Our Ref: R/2016/1/C
File No: MP 08_0098 MOD 13

Modification Request for The Star (MP08_0098 MOD 13) – 20-80 Pyrmont Street, Pyrmont

The City of Sydney (the City) has reviewed the information provided as part of the public exhibition and **objects** to the Section 75W modification of the project approval.

scale	Not to Scale	first issued	2/11/18
project code	sheet no.	revision	
SM13	AF8201	DA01

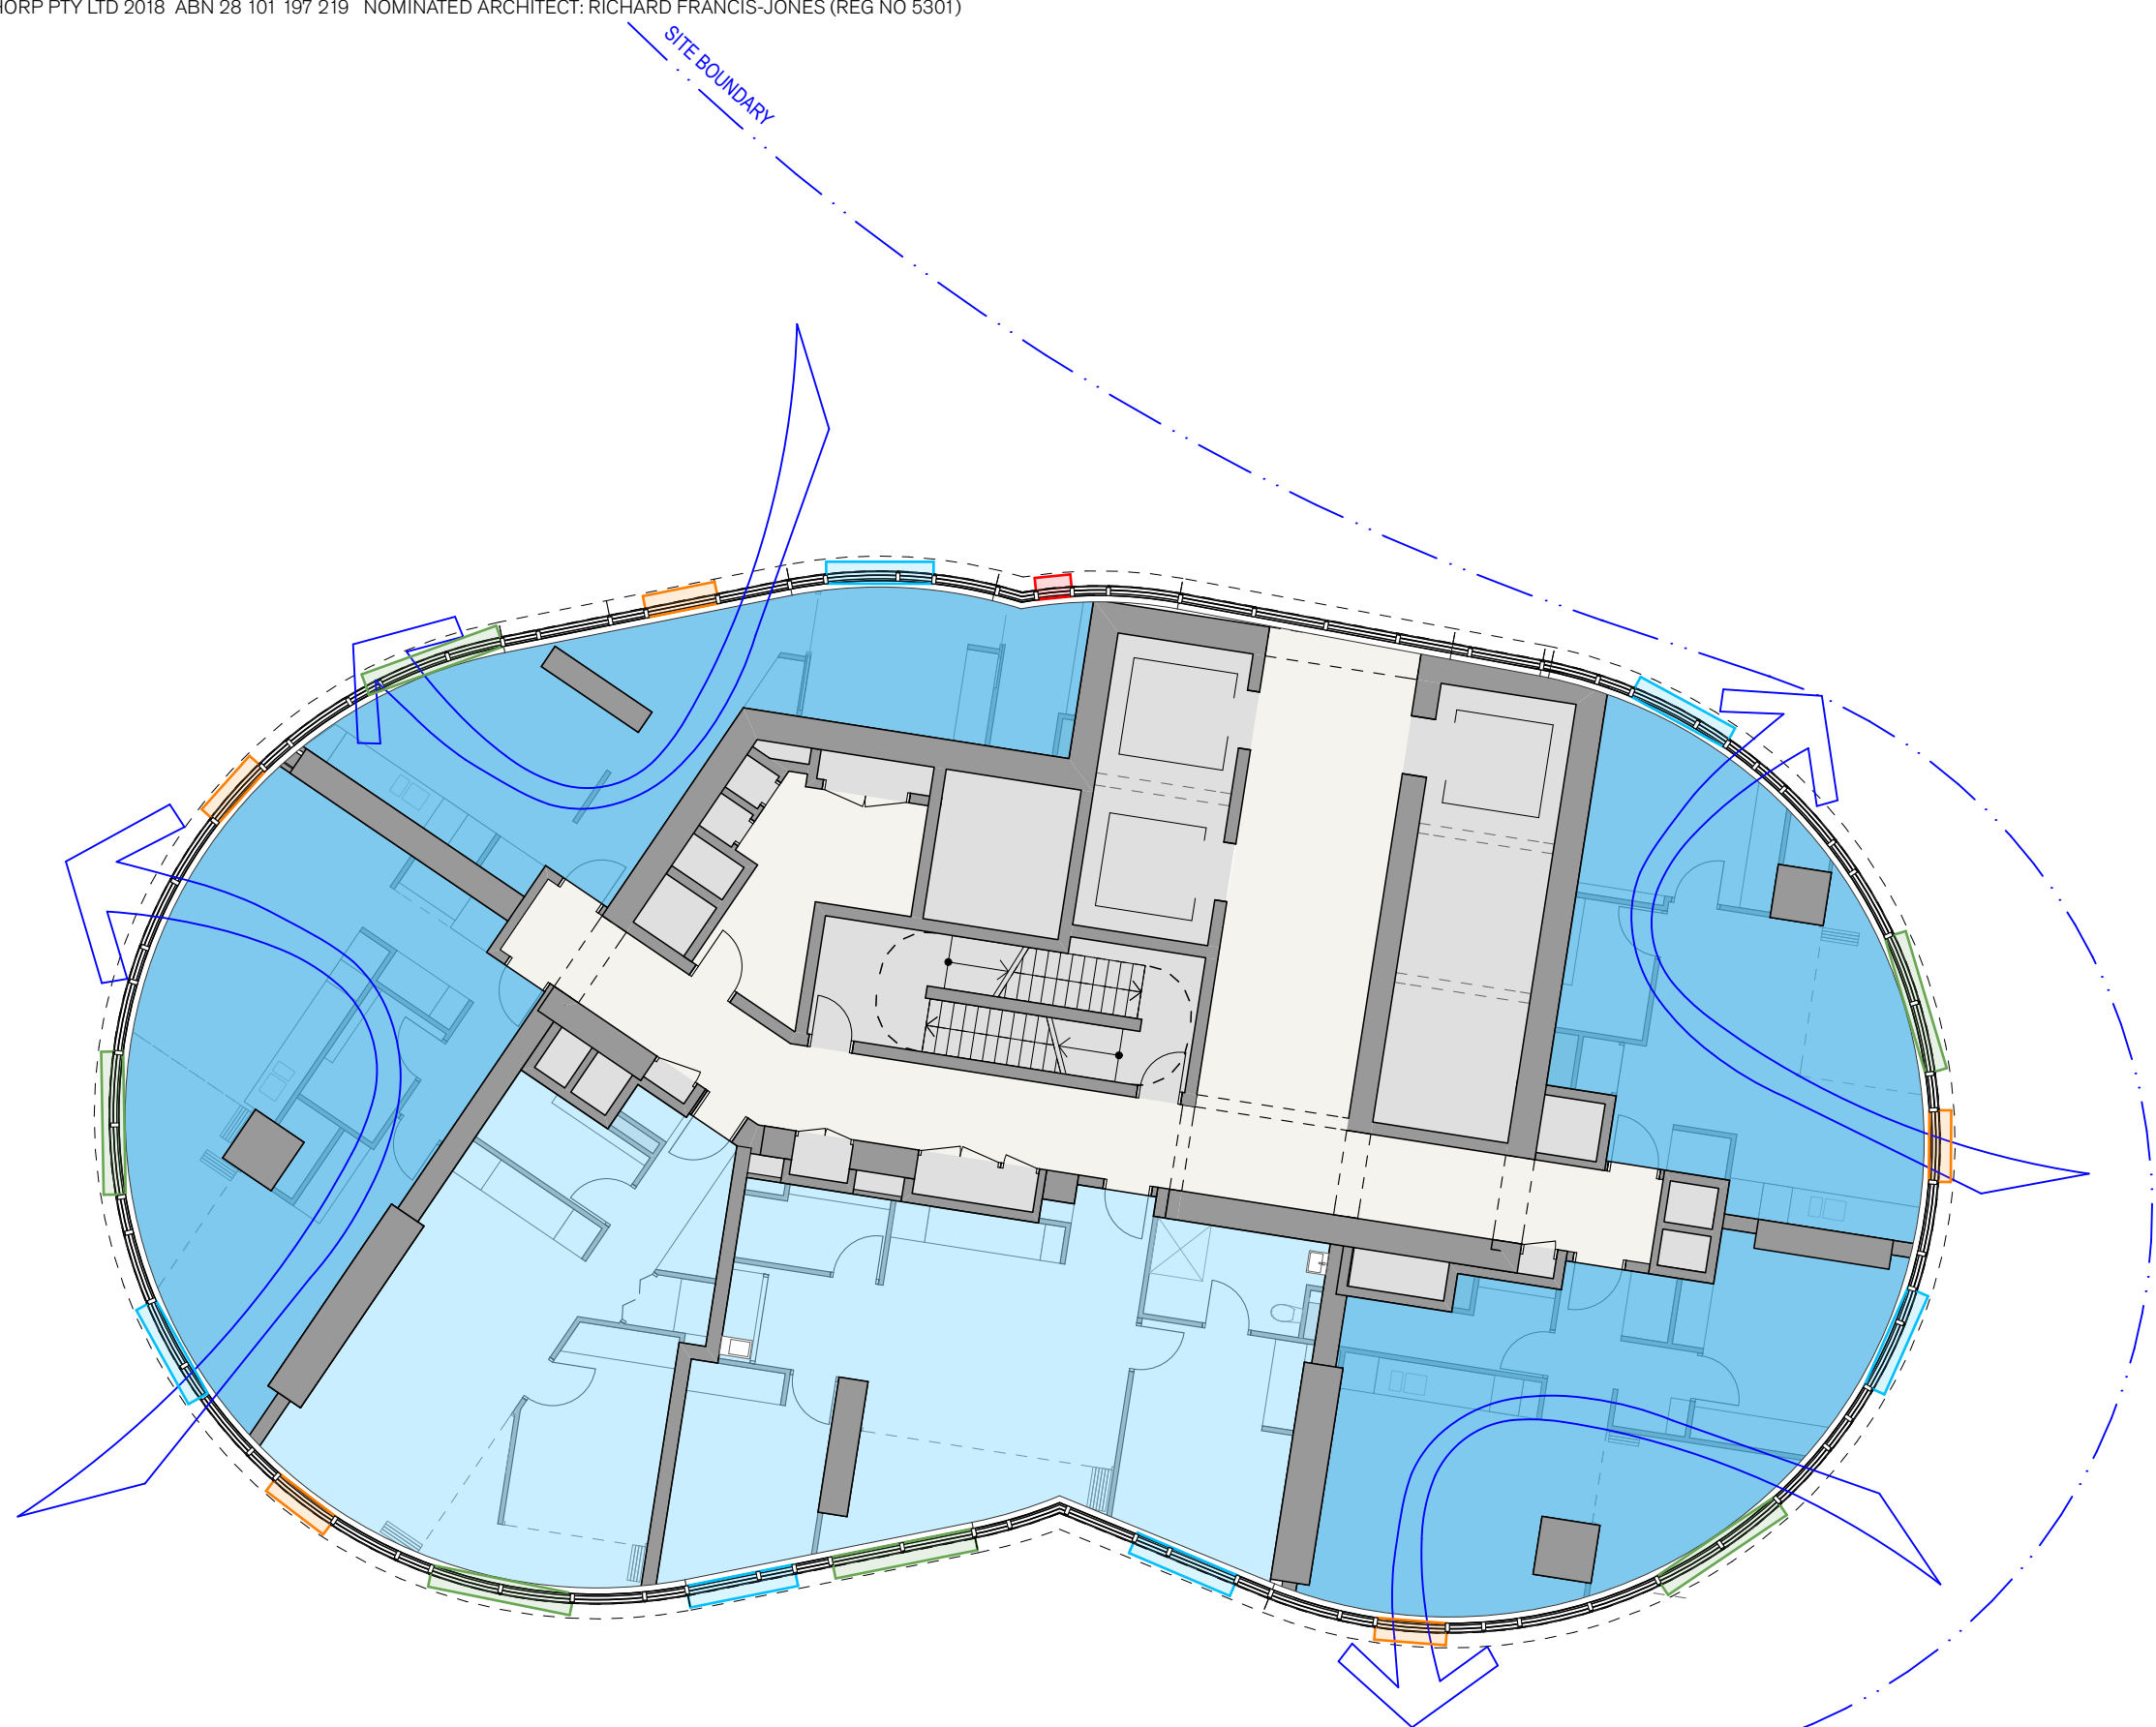
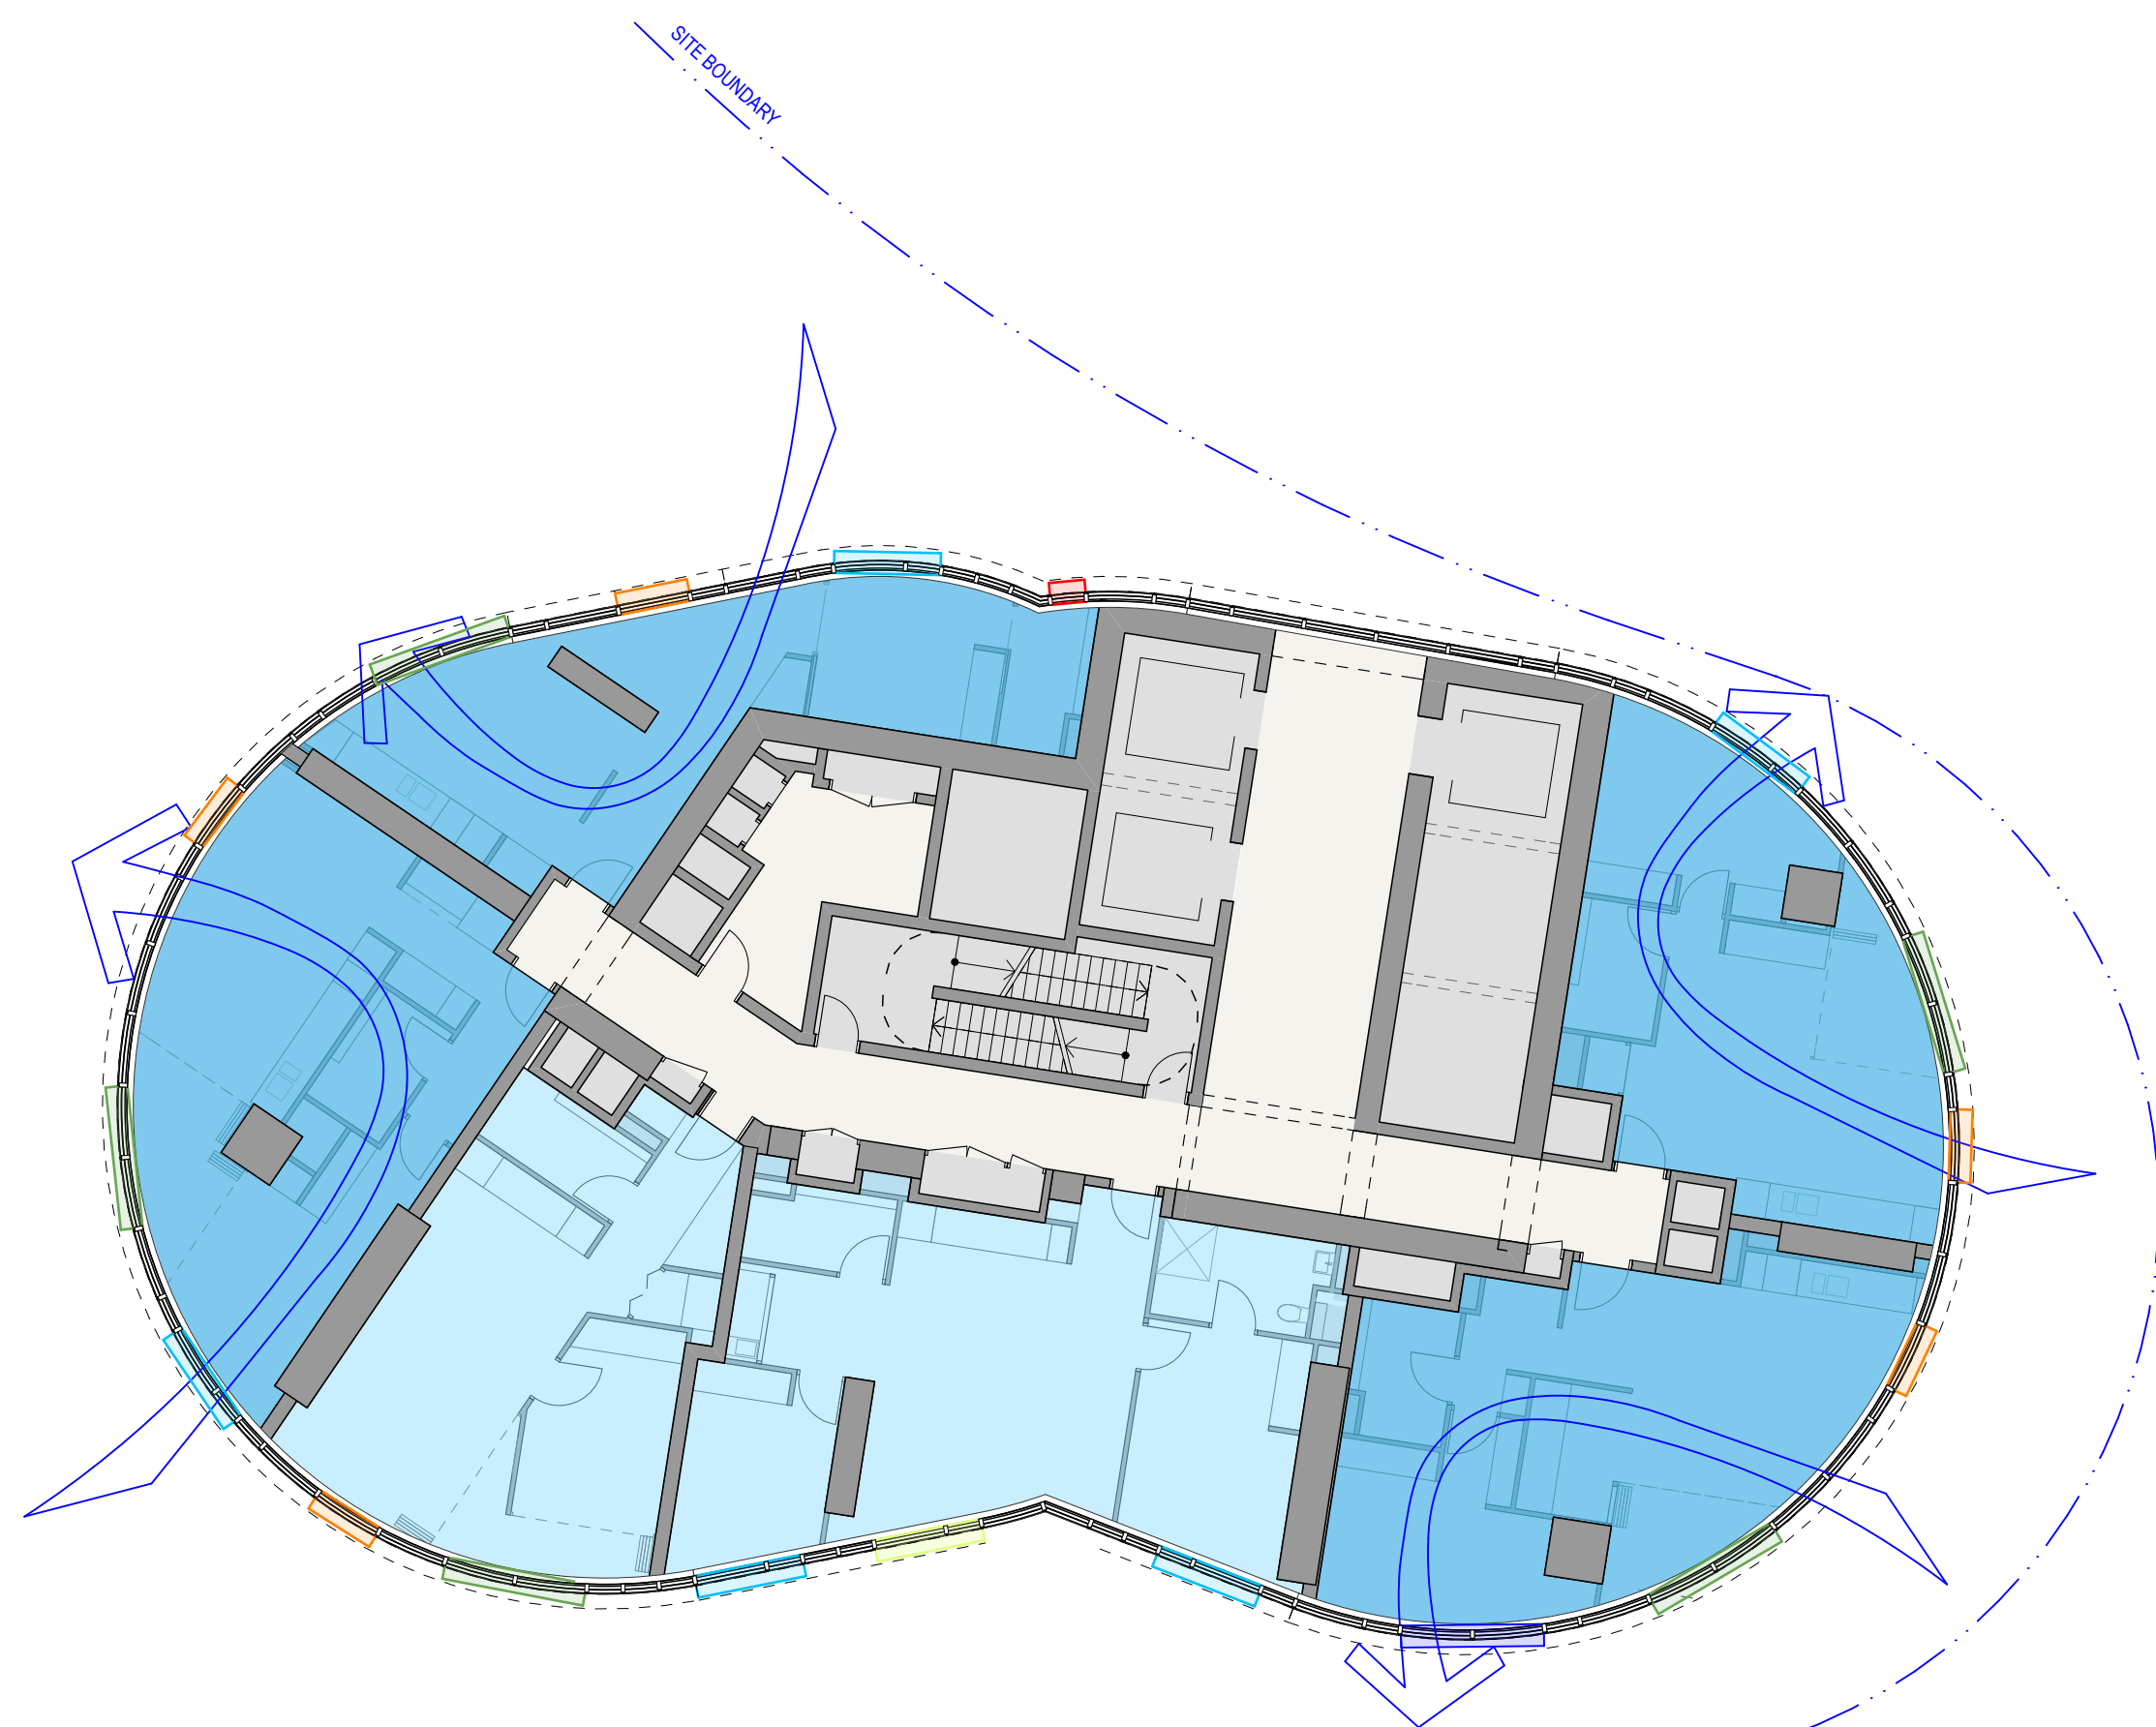
- Inadequate detail has been provided to establish how the natural ventilation requirements of the ADG will be met. The architectural plans do not show *any* operable windows to apartments. All glazing, including to wintergardens, is drawn in plan to appear as a curtain wall. This provides an unacceptable level of amenity.

- The Noise Impact Assessment states that all residential windows will need to remain closed with mechanical ventilation relied upon to meet required internal noise levels. This solution does not comply with Objective 4B-1 in the ADG requiring all habitable rooms to be naturally ventilated.

- 70% of apartments located below level 10 of the building are to be naturally cross ventilated. Due to the apparent curtain wall sealing all windows, no apartments appear to be naturally cross ventilated.
